City of Portland, Maine - Building or Use Permit Application

PERMIT ISSUED	
Permit No: 01-0794	Issue Date: JUL - 6 2001
CBL: 292 A038001	
Location of Construction: 50 Maggie Ln	Owner Name: Maggie Lane Development Llc
Business Name: n/a	Contractor Name: Custom Build Homes of Maine
Lessee/Buyer's Name: n/a	Phone: 207-892-3149
Phone: n/a	Permit Type: Z.P.U. Family
Zone: R-S

BUILDING PERMIT REPORT

REASON FOR PERMIT: To Construct a duplex dwelling unit

RIGHT ELEVATION

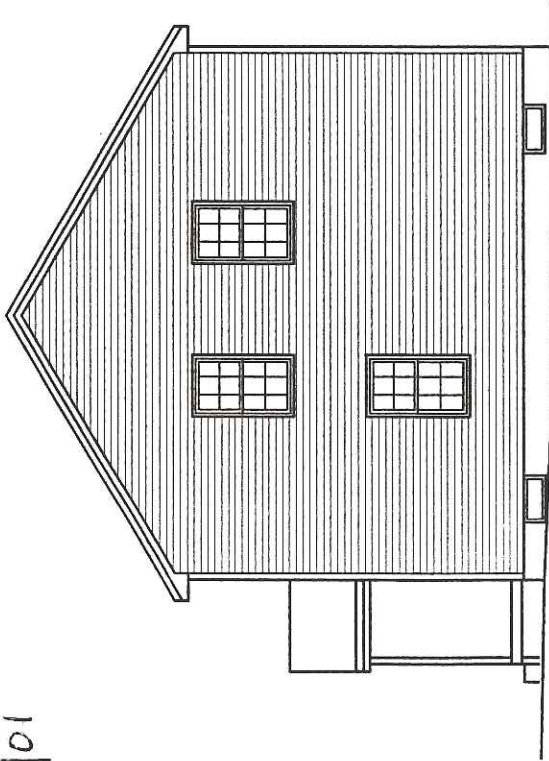
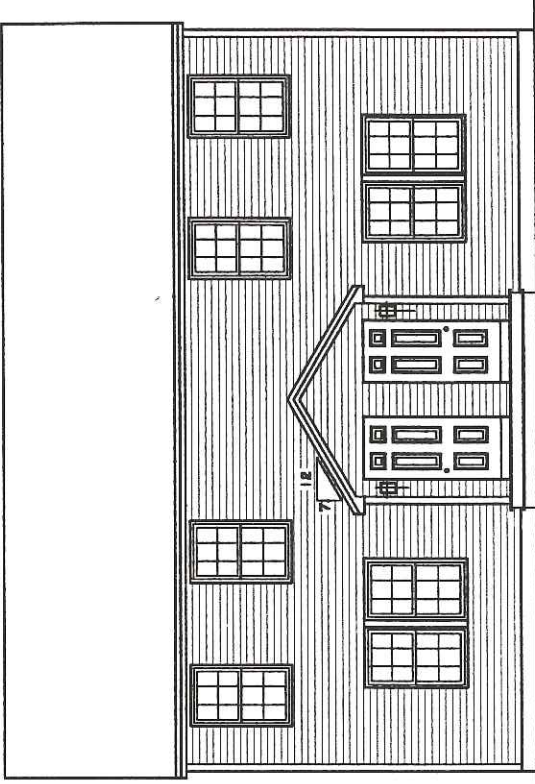
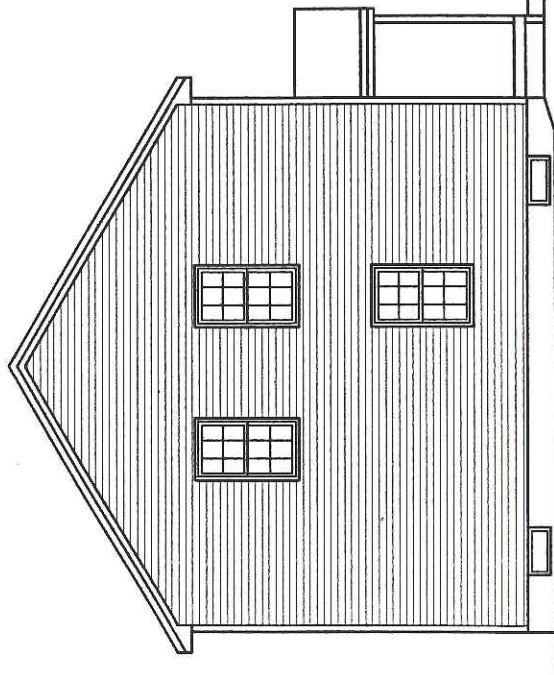
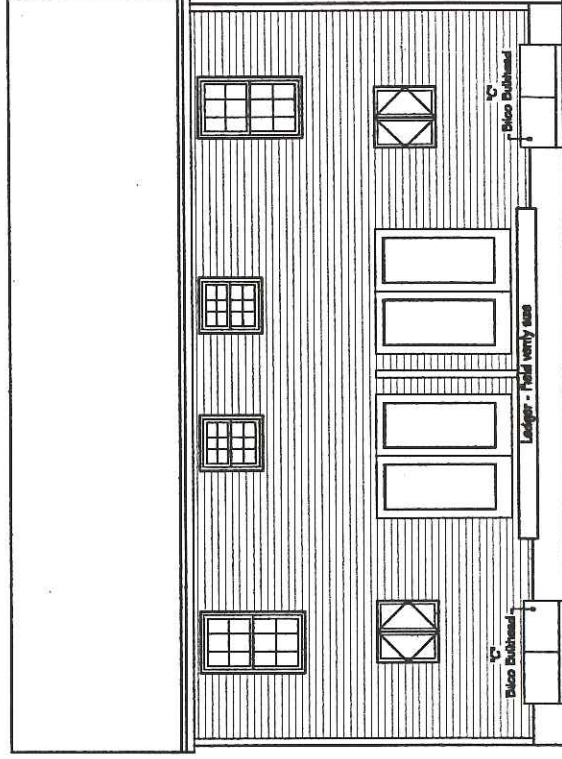
NO DAYLIGHT BASEMENTS SHOWN
